Our Reference: SYD15/01376/04 (A13858389)
Department's Ref: SSD 7372

PROPOSED PRIMARY SCHOOL IN O'CONNELL STREET, PARRAMATTA

DRAWING TITLE
SITE PLAN

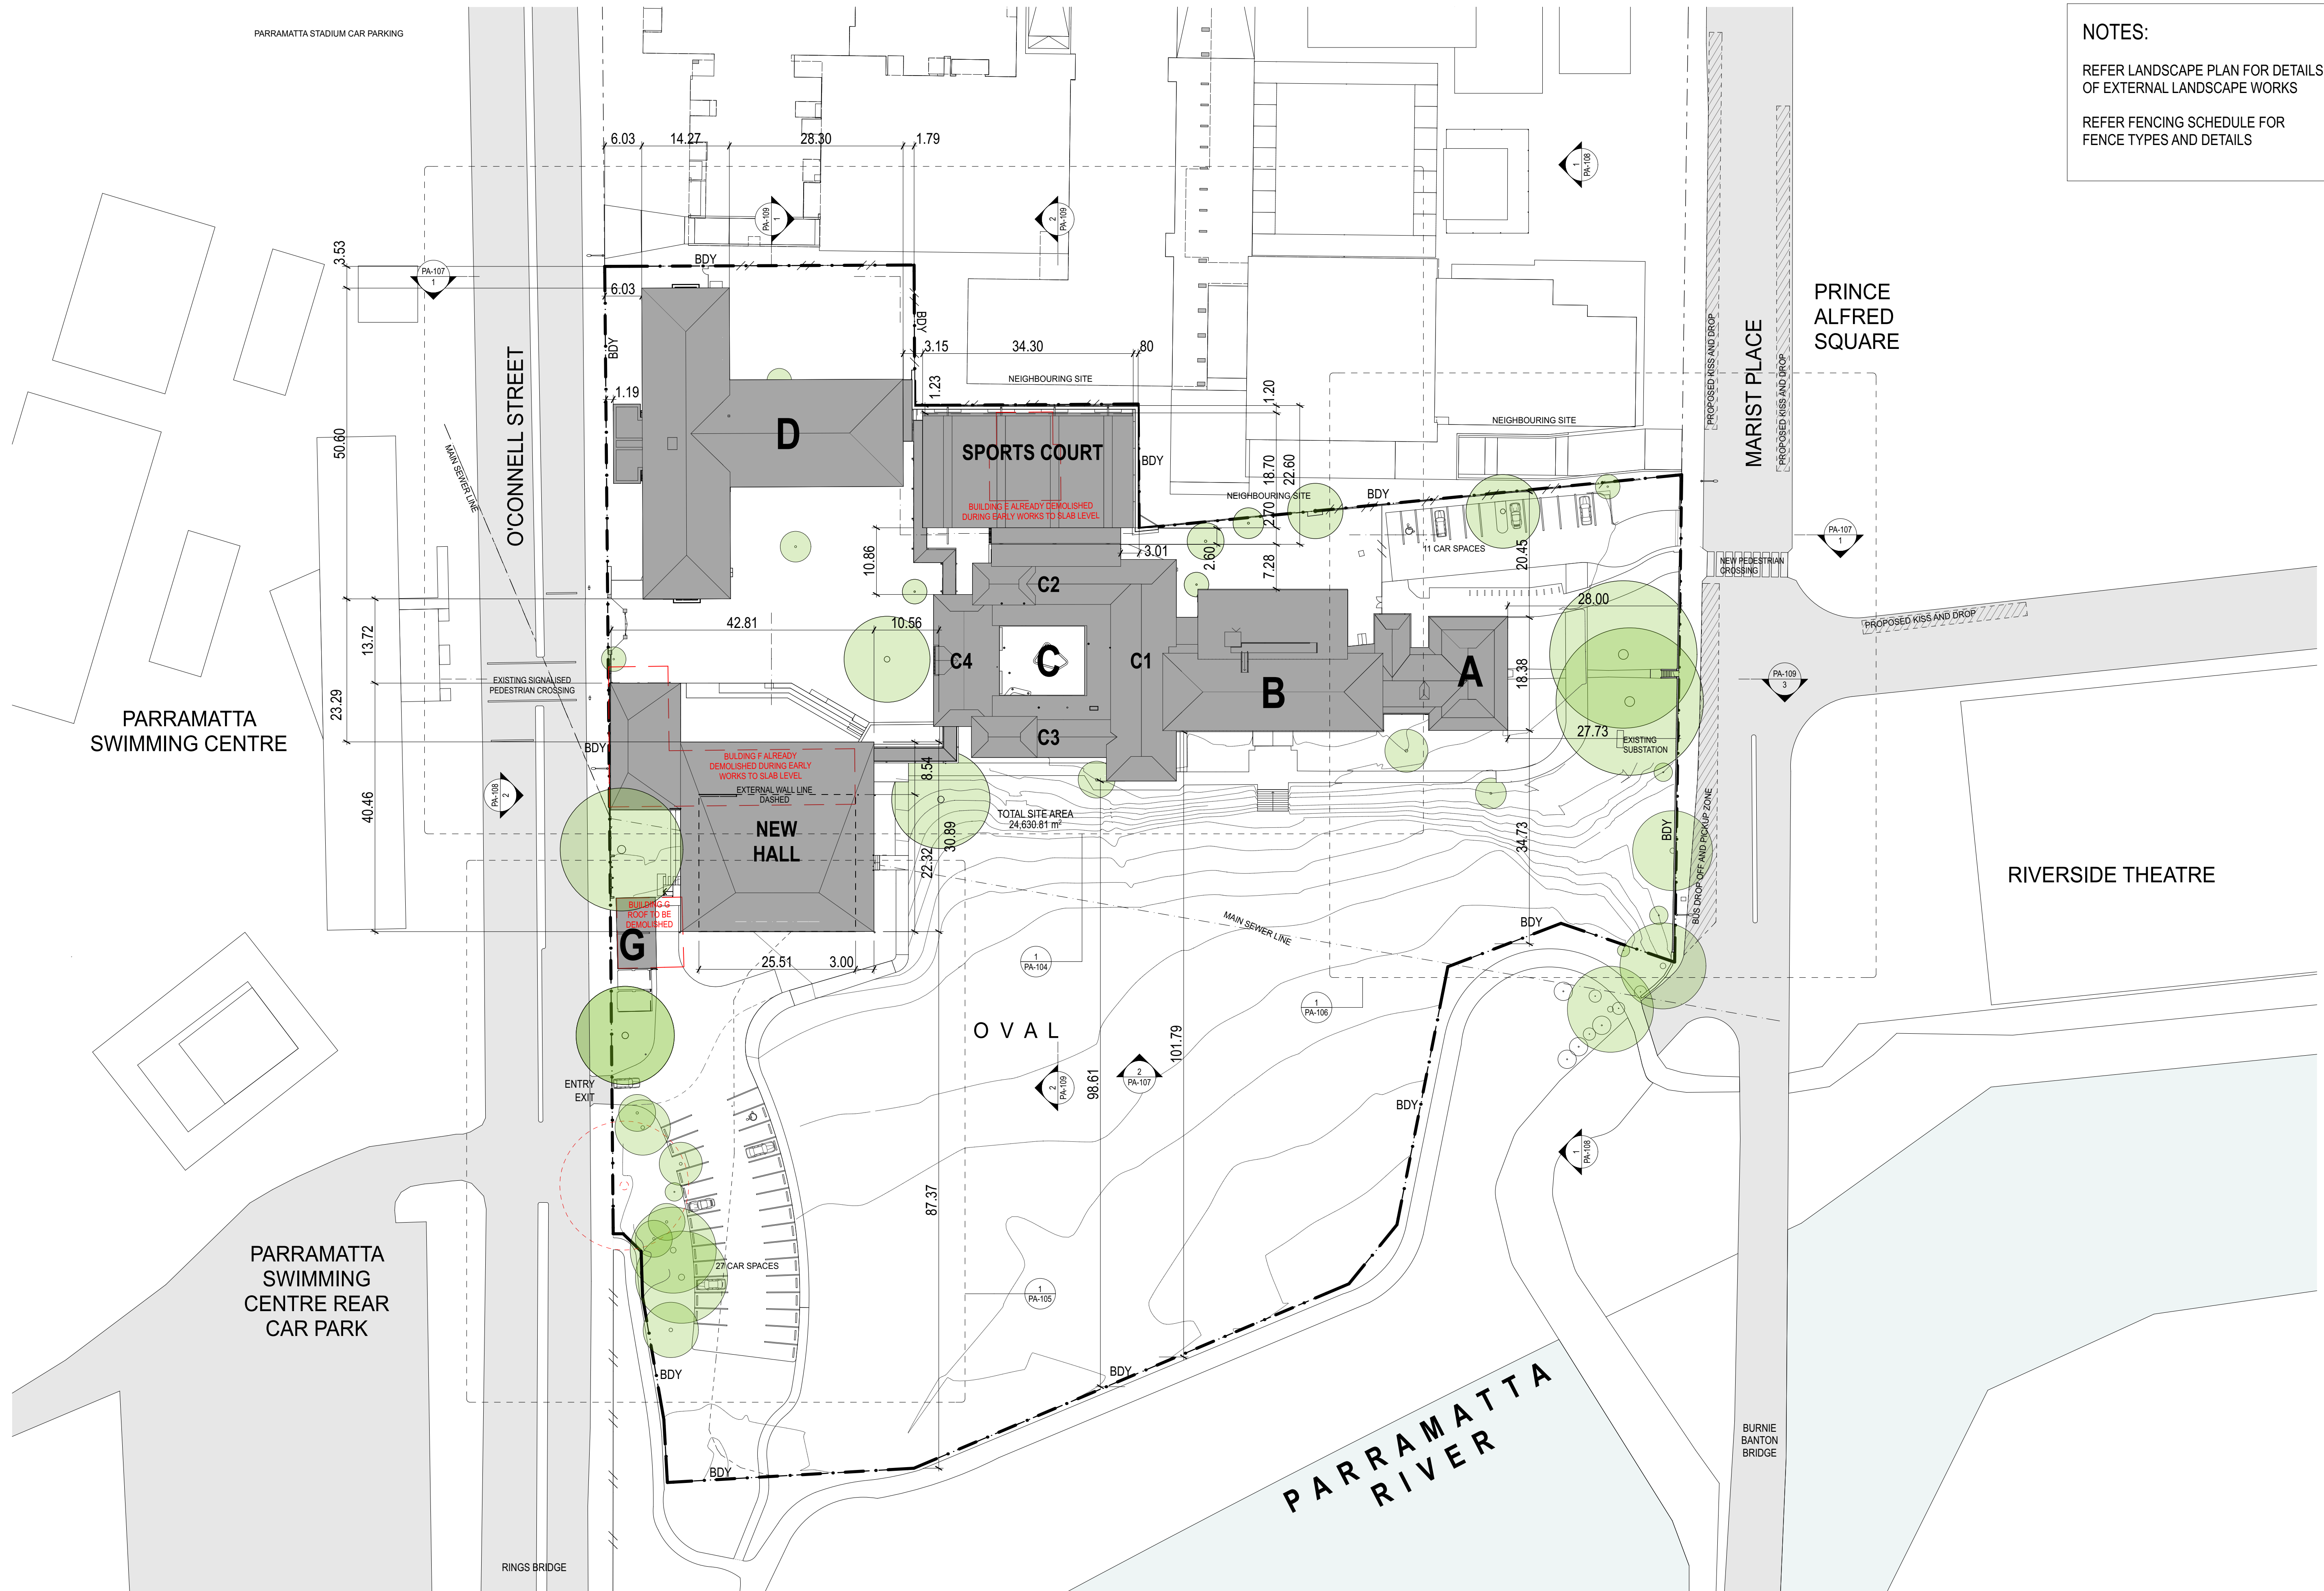
1. Roads and Maritime's correspondence dated 24 March 2016 clearly indicated that; Roads and Maritime would object to any pedestrian access from the proposed School to O'Connell Street to prevent need for a School Zone on a major feeder road into Parramatta; which is consistent with requirements that have been placed on Catholic Education for the adjoining site. A 40 km/h School Zone would have an adverse impact on the traffic flow in this location which is not acceptable to Roads and Maritime.

Roads and Maritime does not support this application as its current form. Upon receipt of the amended information satisfying the above Roads and Maritime will review this application further and respond to you accordingly.
